CITY OF PORTLAND BUILDING PERMIT

Located At 43 QUEBEC ST

Job ID: 2011-11-2677-ALTR

Jonathan Rioux - RE: 43 Quebec Street Addition- LandMarx Construction

*MATHews BROTHERS NFRC CERTIFIED CENTER UNIT PERFORMANCE

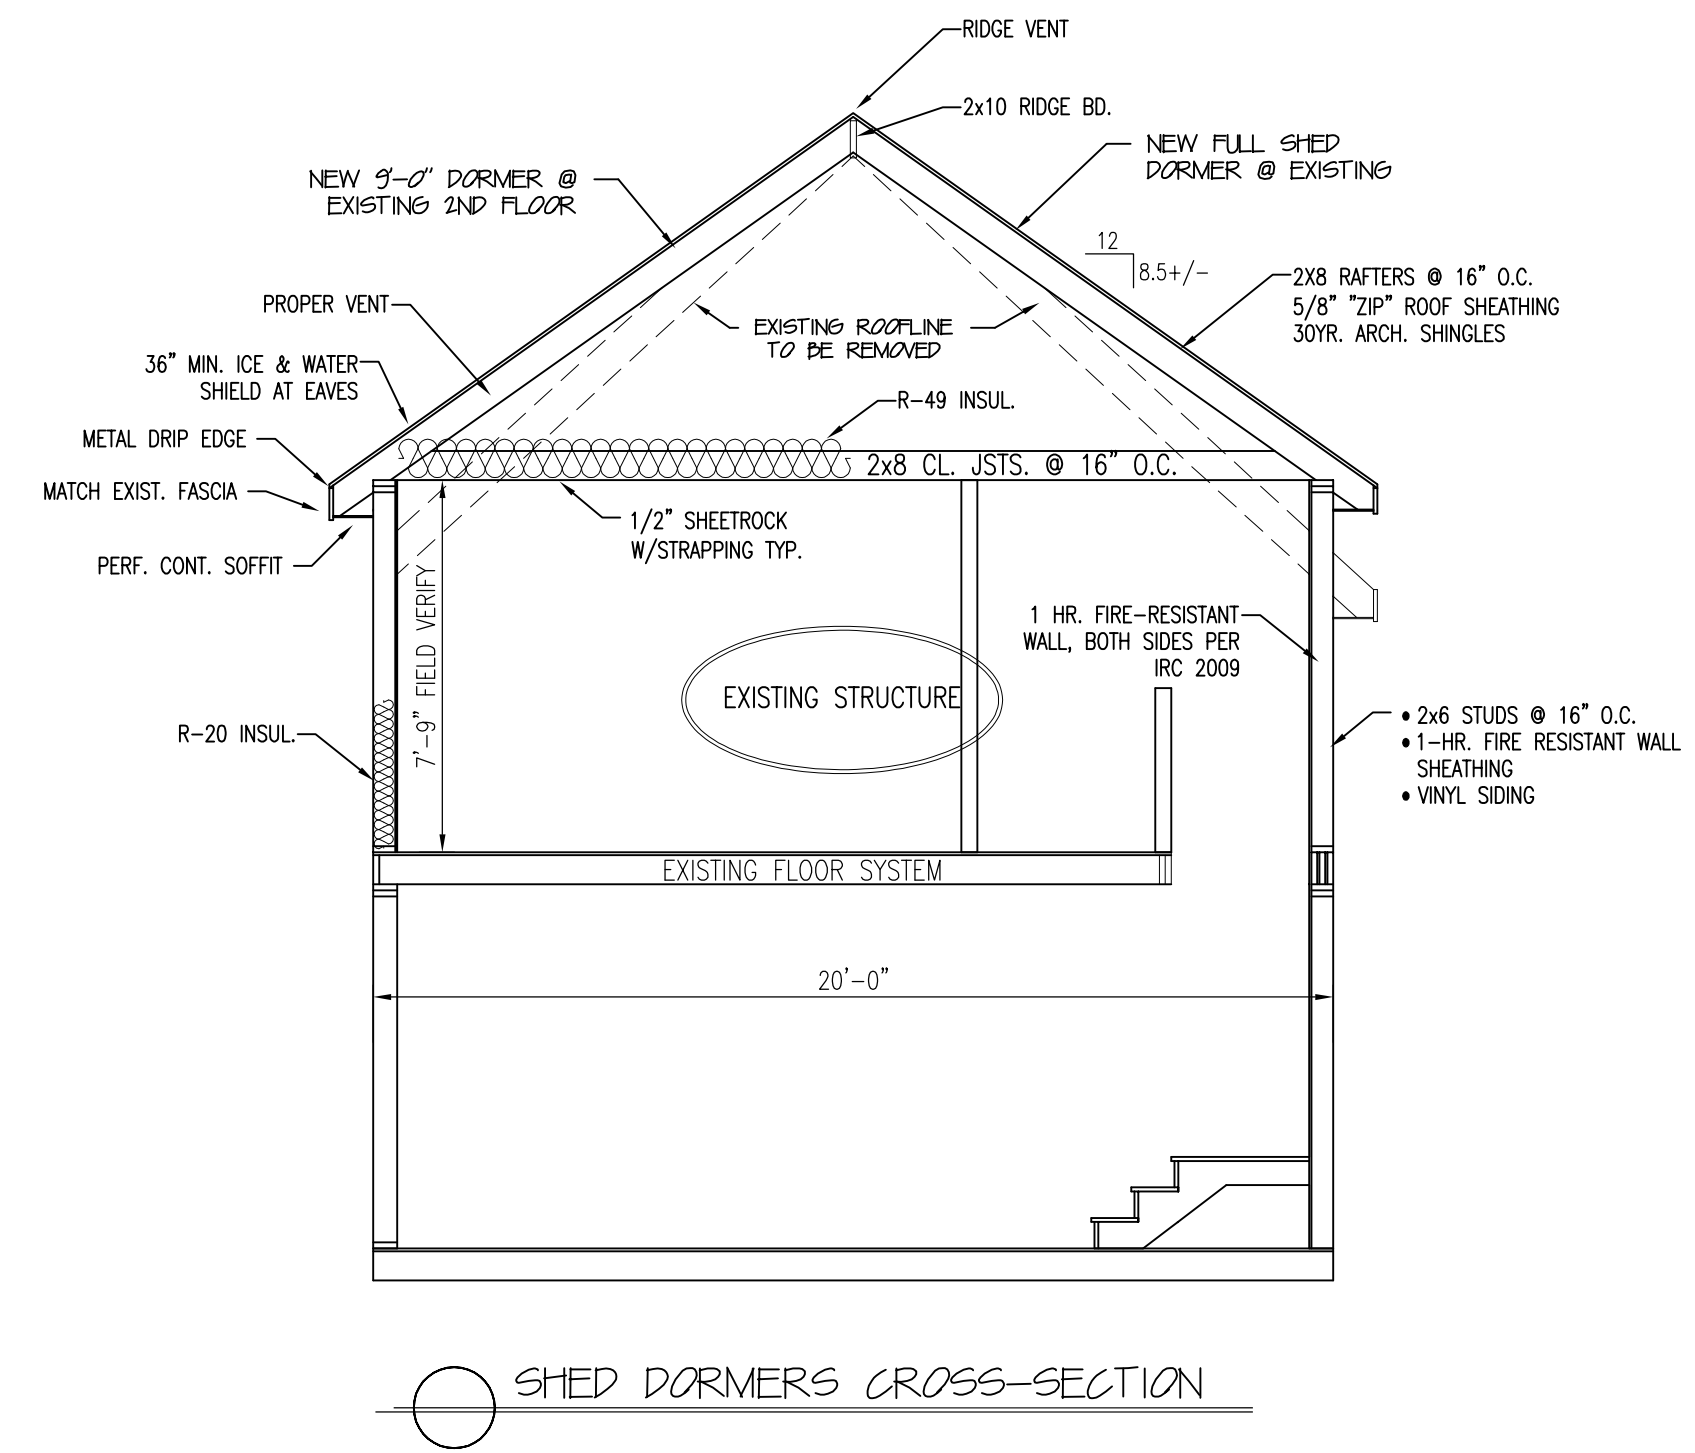
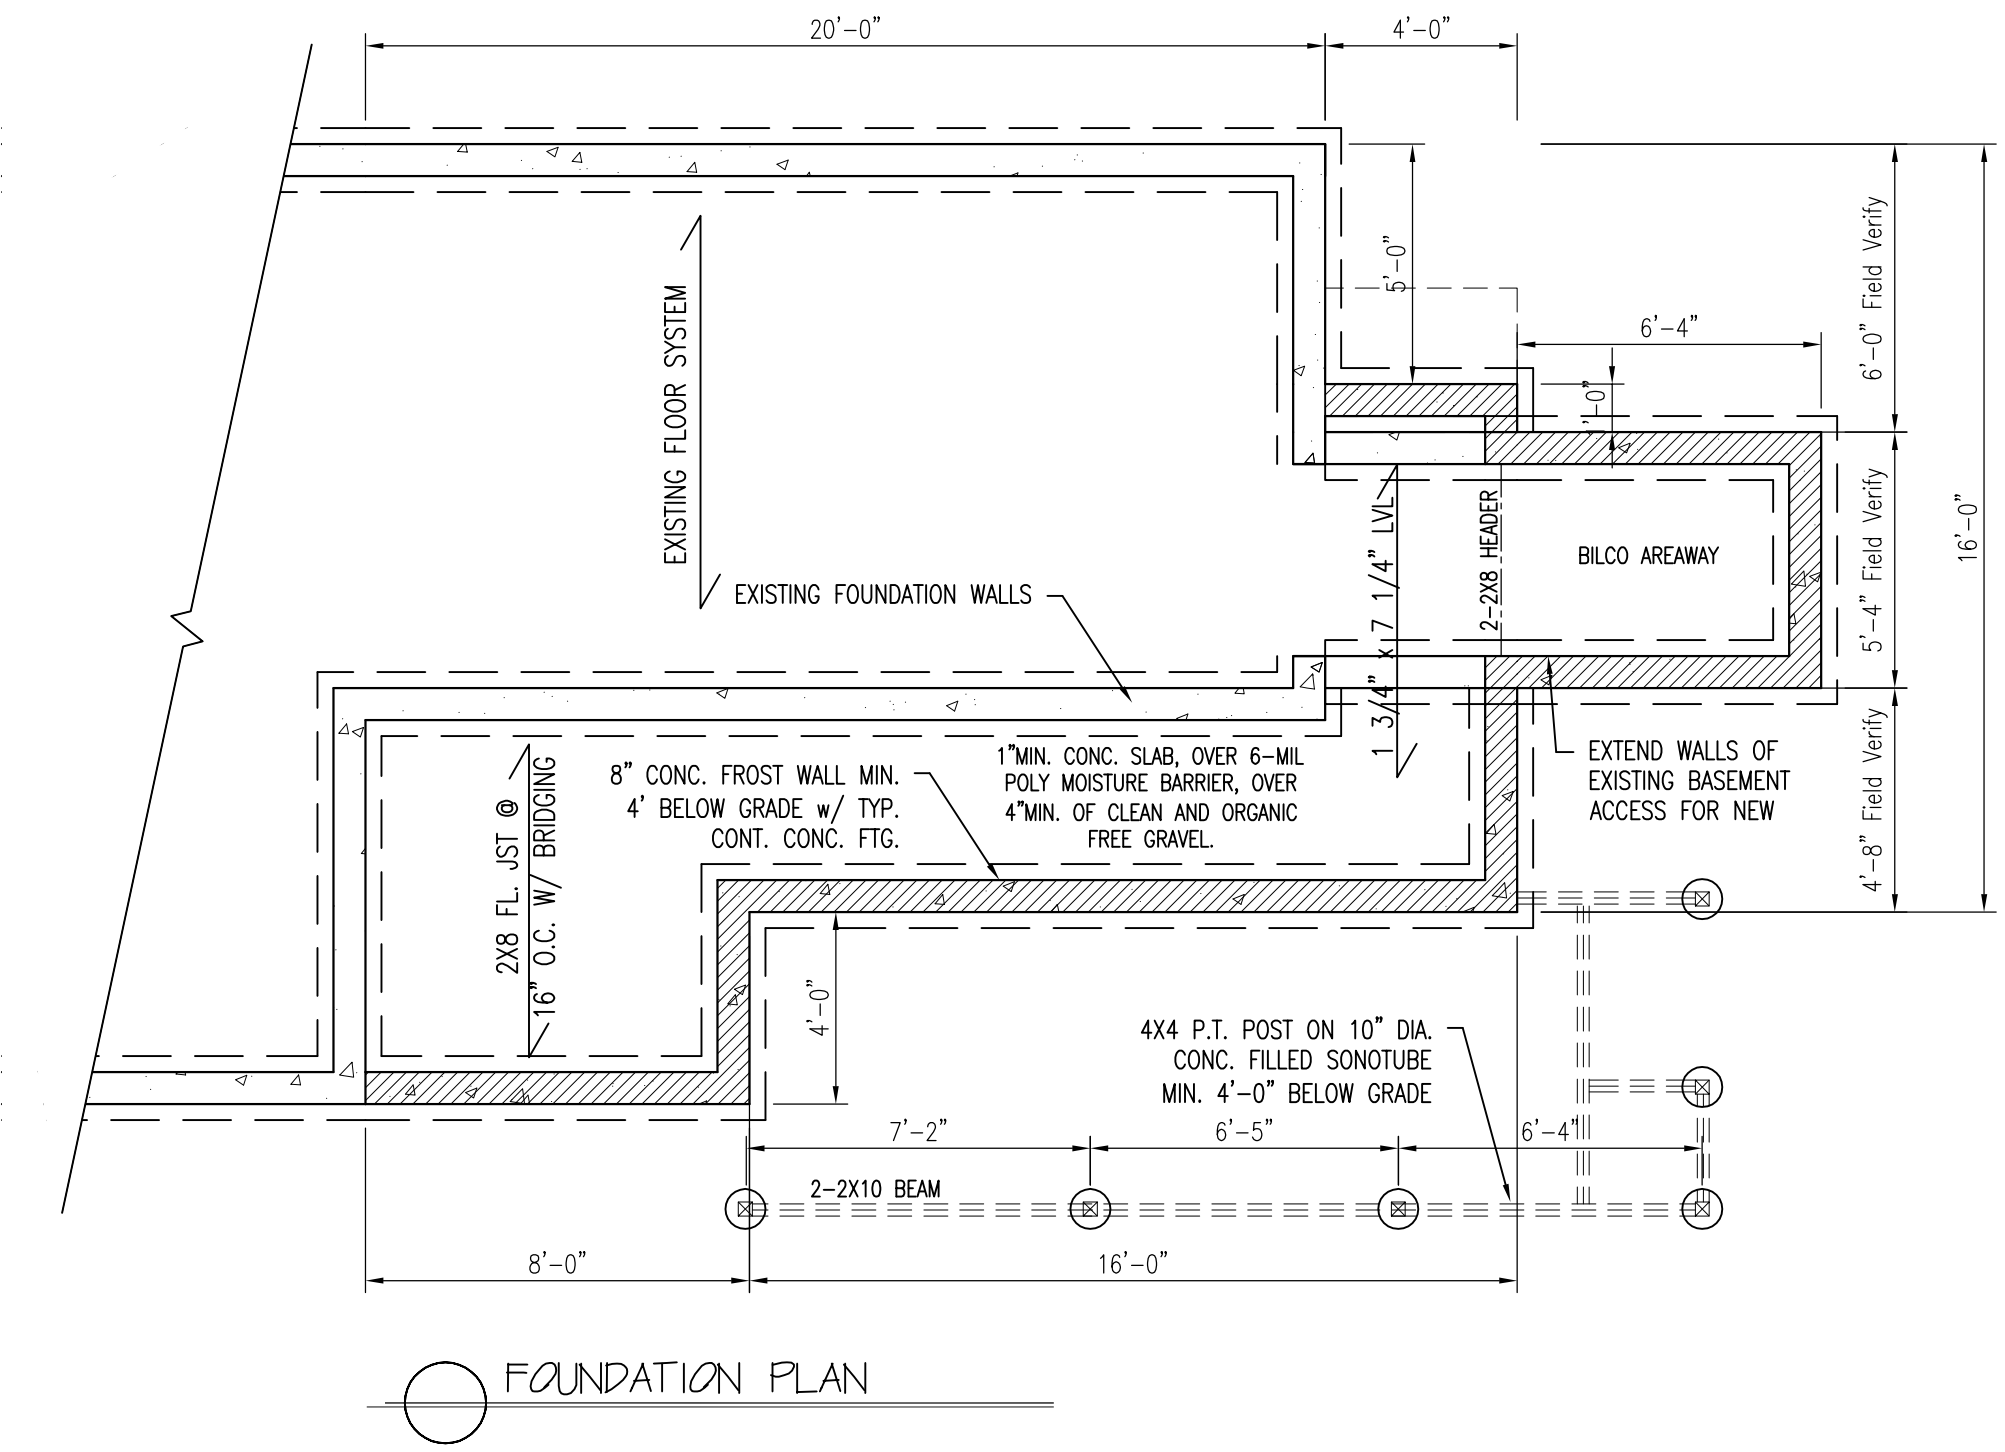
- A Second Floor to Foundation- Floor Plan showing how far the 2 X 8 inch joist are spanning w/ a cross section of the center Girder (if any).
- A cross section of the slopped second floor bathroom ceiling (showing fixture clearance headroom), see Section R305.1.
- What materials are being used for the 1 Hour Wall, see Section R302?
- How far are you spanning the (2) 2 X 10 Inch Beam between each Sona tube, see Table R502.5(1)?
- Is the interior stairwell changing to the new addition?
- Jonathan Rioux
 Code Enforcement Officer/ Plan Reviewer

- A Second Floor to Foundation- Floor Plan showing how far the 2 X 8 inch joist are spanning w/ a cross section of the center Girder (if any). Dimensions have been added to the floor plan and notes added to existing cross-section
- A cross section of the sloped second floor bathroom ceiling (showing fixture clearance headroom), see Section R305.1. – the only sloped clg. In the bathroom is in the corner where the linen shelves are, thus no fixture clearance issues- see plan & section.
- What materials are being used for the 1 Hour Wall, see Section R302? Notes have been added to x-sxn & floor plans
- How far are you spanning the (2) 2 X 10 Inch Beam between each Sona tube, see Table R502.5(1)? More Dimensions have been added to floor plan
- Is the interior stairwell changing to the new addition? No changes here.
